Ferring Parish Council
Ms Nadine Phibbs
1 Elm Park
Ferring
Worthing, West Sussex
BN12 5RN

Your Ref: OWPC20779
Our Ref: FG/202/18/HH
Please ask for:
Mr A Wood

Amendments to FG/160/17/HH (Demolition of existing rear conservatory, side garage door & car port & erection of single storey rear extension, side garage with pitched roof, replacement of existing enclosed porch, replacement with timber posts & removal of existing front windows & replacement with faceted windows) to amend roof from pitched to flat. Creation mono-pitch roof over existing garage door which is to remain. Existing garage car port roof to be removed and side wall infilled.
26 Beehive Lane Ferring

PROPOSED FLOOR PLANS &
ELEVATIONS

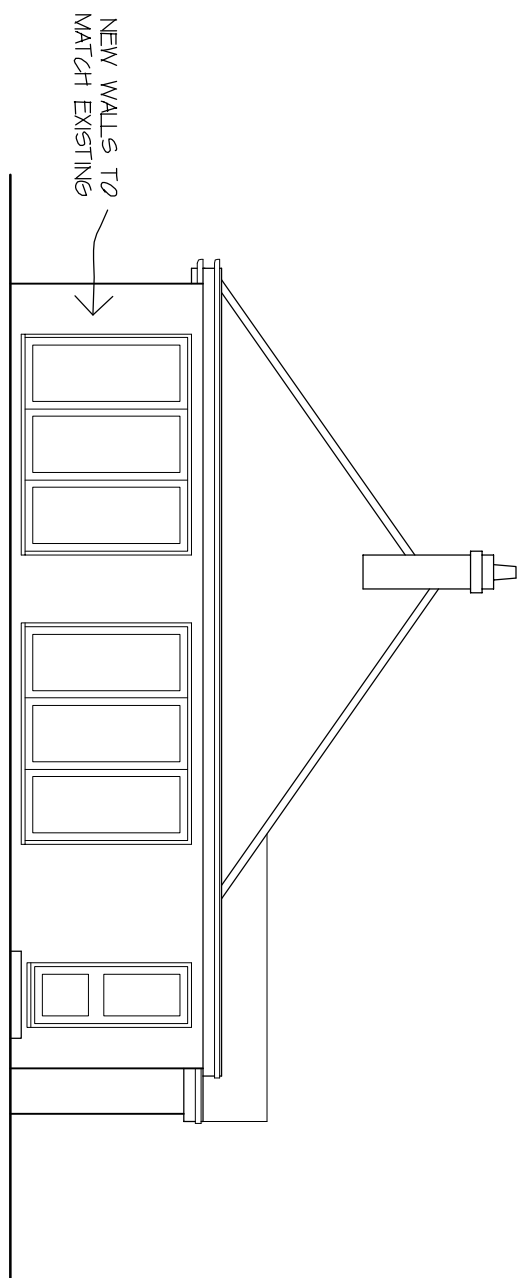
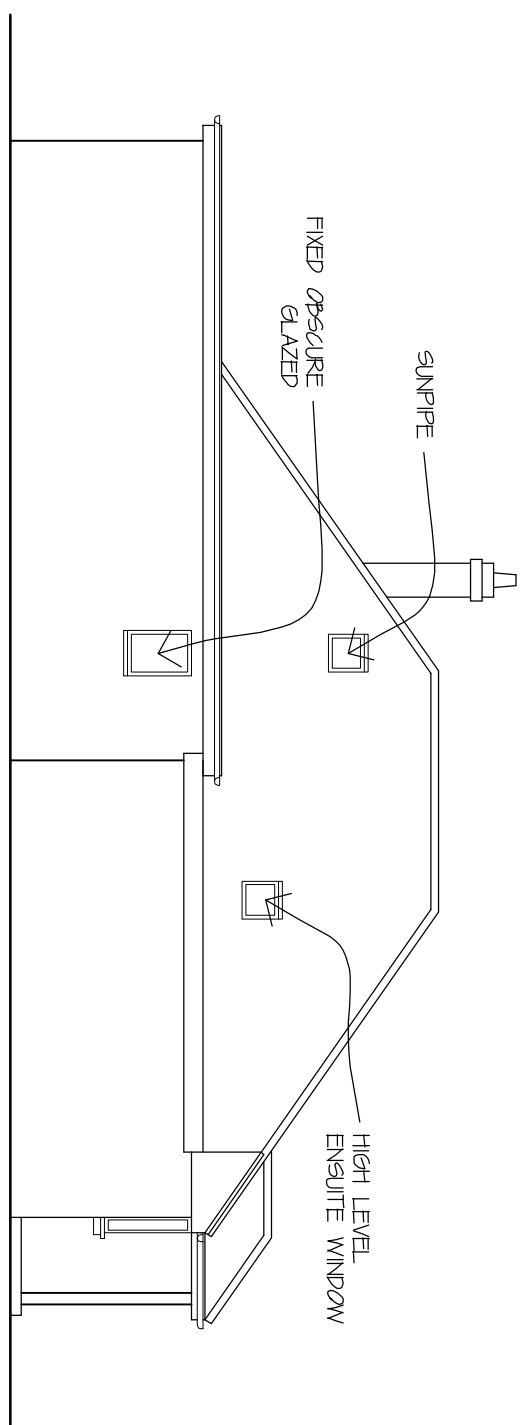
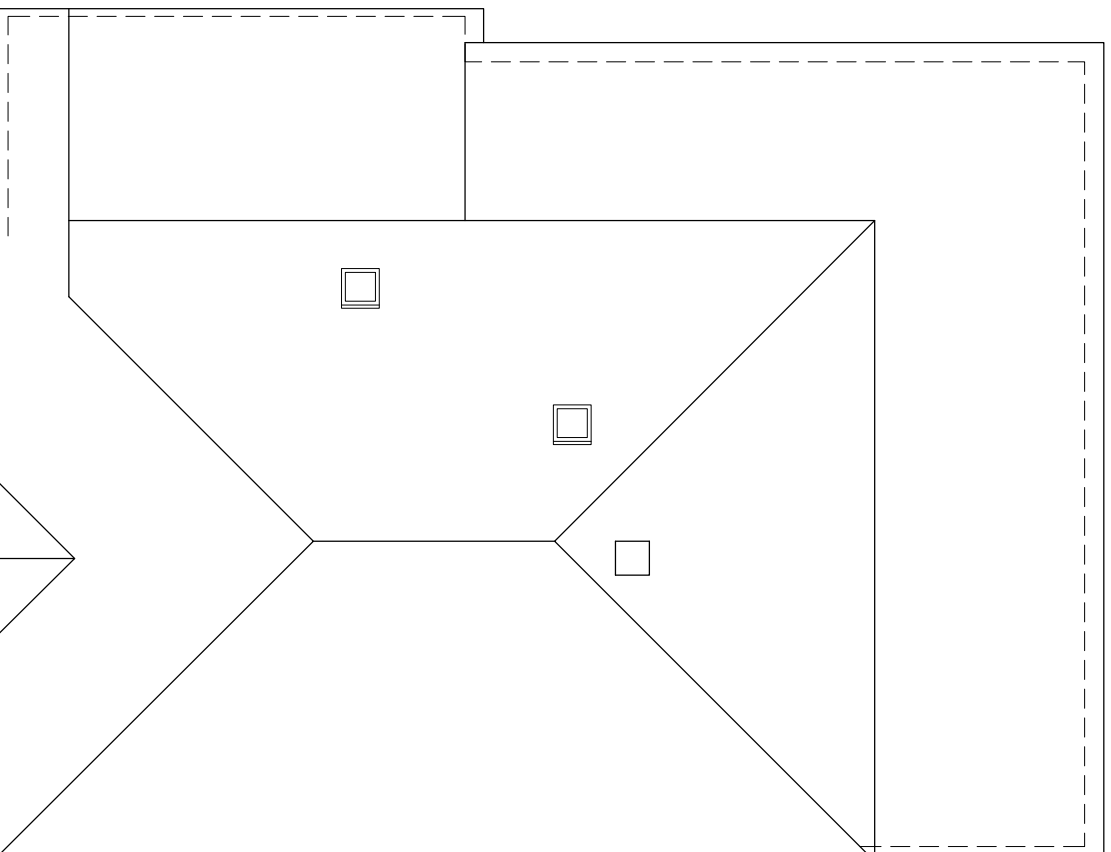
The roof design does not conform to the applicants own drawing and specification in the Proposed Floor Plans & Elevations - 1231/03 on which approval and conditions was based.

The adverse impact on the residential amenity of the neighbouring property by the deliberate disregard of the design condition is considerable and unacceptable as can be seen from the photographs supplied by resident of the neighbouring property (2, Jersey Road).

The specific eaves height and roof design was quite rightly made conditional in order that the development would not "give rise to unacceptably adverse overbearing,

overshadowing or overlooking impacts" on 2, Jersey Road.
The current application makes no provision to otherwise avoid or offset those adverse impacts identified by the Officer.

Ferring Parish Council therefore objects to this application and requests that the original conditions are enforced, without undue delay, to reinstate an acceptable residential amenity standard of which the resident of 2 Jersey Road is now being unlawfully deprived and which the Planning Officer made conditions to ensure was safeguarded in the Report and Decision made on the previous application.
